Ribble Valley Borough Council
Council Offices
Church Walk,
Clitheroe
Lancashire
BB7 2RA

Phone: 0300 123 6780
Email: developeras@lancashire.gov.uk
Your ref: 3/2026/0698
Our ref: 3/2026/0698/HDC/KW
Date: 16 October 2026

Location: Thorn Street Garage Clitheroe BB7 1DN
Proposal: Proposed demolition of 2No. buildings and construction of new garage buildings for general industrial use (Class B2).
Grid Ref: 373843, 441551

The Local Highway Authority (LHA) are in receipt of an application for the proposed demolition of 2No. buildings and construction of new garage buildings for general industrial use (Class B2) at Thorn Street Garage, Clitheroe.

Client: Rufus Carr Ltd		
Project: Proposed Alterations Thorn Street Garage Thorn Street Clitheroe		
Dwg title: Proposed Site Plan		
Scale @ A4: 1:200	Date: 22.07.26	Drawn by: PD
Drawing no. 1830 - 102		Rev: -

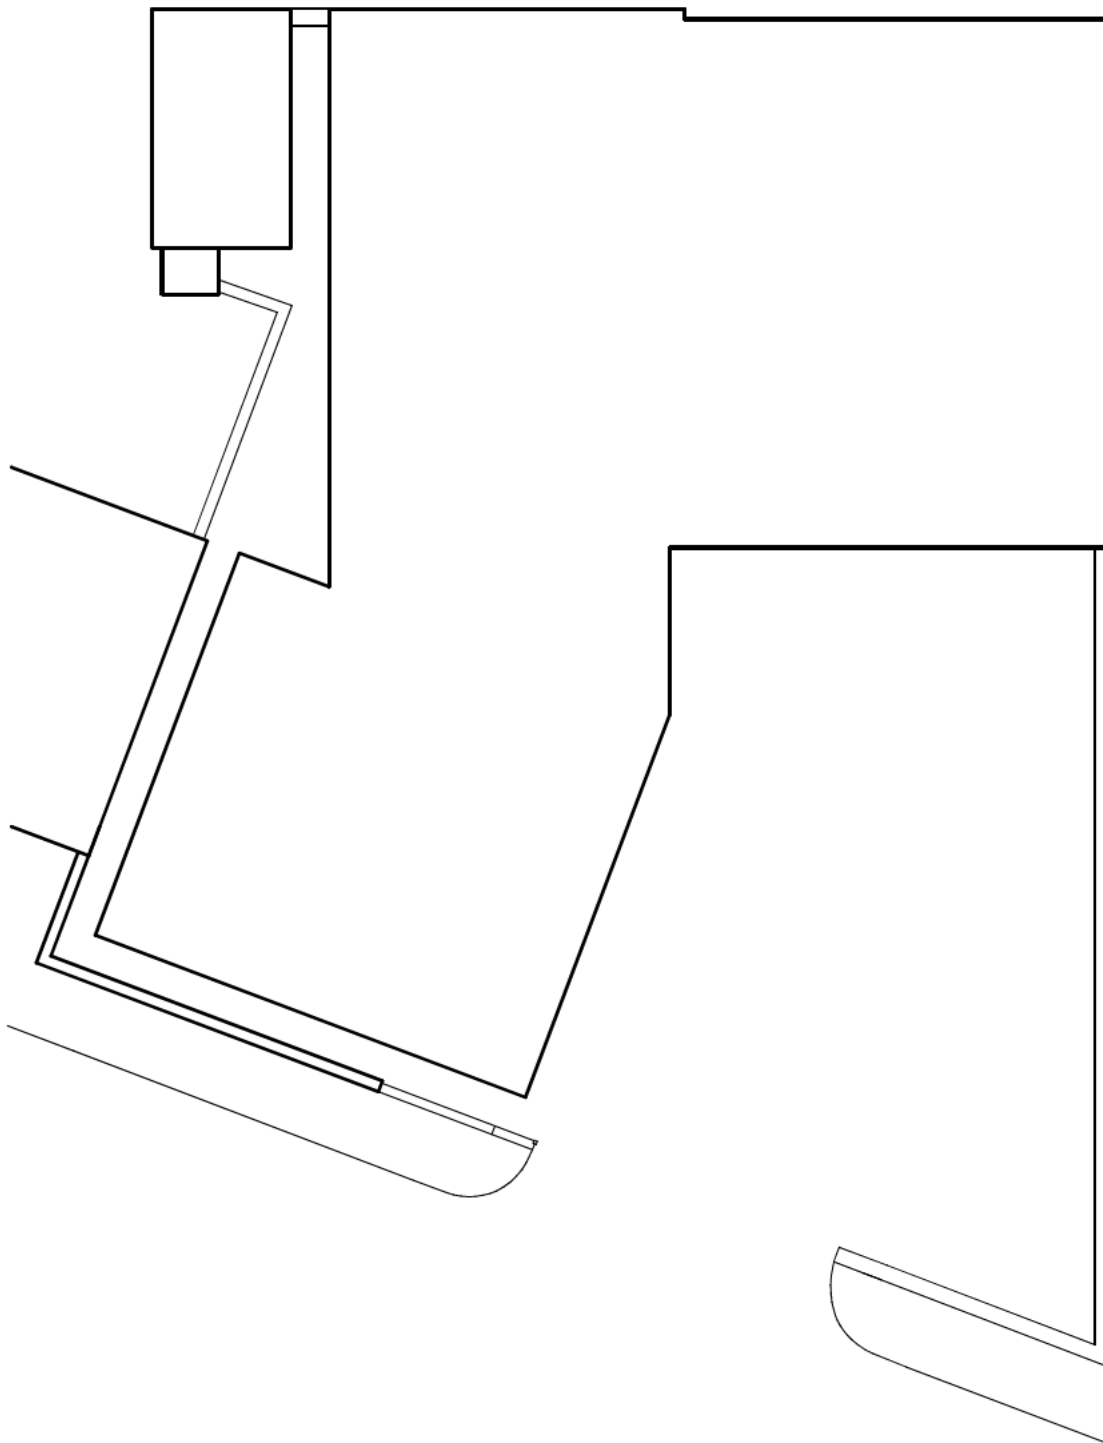
The LHA have reviewed drawing number 1830 – 102 titled Proposed Site Plan and note that a section of external forecourt area is to be retained.

Parking Standards for a B2 use are one parking space per 45 sq m of floor space. Based on the proposed internal floor space of 447 sq m, the LHA expects 10 external parking spaces to be retained on site. The site should also have a designated turning area to ensure vehicles can enter and leave the site in forward gear.

The submitted statement indicates that parking provision will remain unchanged and will continue to be accommodated within the workshop buildings and forecourt. However, no evidence has been provided to demonstrate that the internal areas proposed to accommodate parking are surplus to the operational requirements of the business. In the case of a motor vehicle repair garage, internal floor space is primarily used for vehicle servicing, repairs, MOT testing, and storage of equipment. Such areas form part of the operational workspace and should not automatically be considered available parking provision.

Parking standards are intended to ensure that sufficient parking is available without prejudicing the efficient operation of a site. Where vehicles are routinely parked within workshop areas as part of the business operation, these spaces cannot reliably be counted towards the site's parking provision. Failure to distinguish between operational vehicle storage and dedicated parking provision risks overstating the level of parking available and may result in overspill parking on the public highway.

Historical views of the site reviewed as part of the LHA's desktop study show that the external forecourt area within the site has historically been well used for parking and, as such, the LHA need to ensure that any loss of external space does not result in parking on the highway. Thorn Street often experiences congestion due to the railway level crossing situated 100m from the site. Any on street parking associated with the development has the potential to reduce the effective width of the carriageway, impede the free flow of traffic, and exacerbate existing congestion issues within the area.

As such, it is expected that a plan be provided showing parking spaces measuring 2.4m by 5m and a dedicated turning area to ensure development of the site does not lead to an overspill of parking on the highway.

Insufficient information has been provided to demonstrate that the development can accommodate adequate parking and vehicle manoeuvring within the site. The submitted details do not clearly identify the number of dedicated parking spaces to be retained, nor do they demonstrate that the areas proposed for parking are genuinely available and not required for the operational needs of the vehicle repair business. Furthermore, no evidence has been provided to show that vehicles can turn within the site and exit in a forward gear.

Accordingly, the applicant should provide a revised site layout identifying a minimum of 10 dedicated parking spaces (measuring 2.4m x 5.0m) together with a suitable turning area.
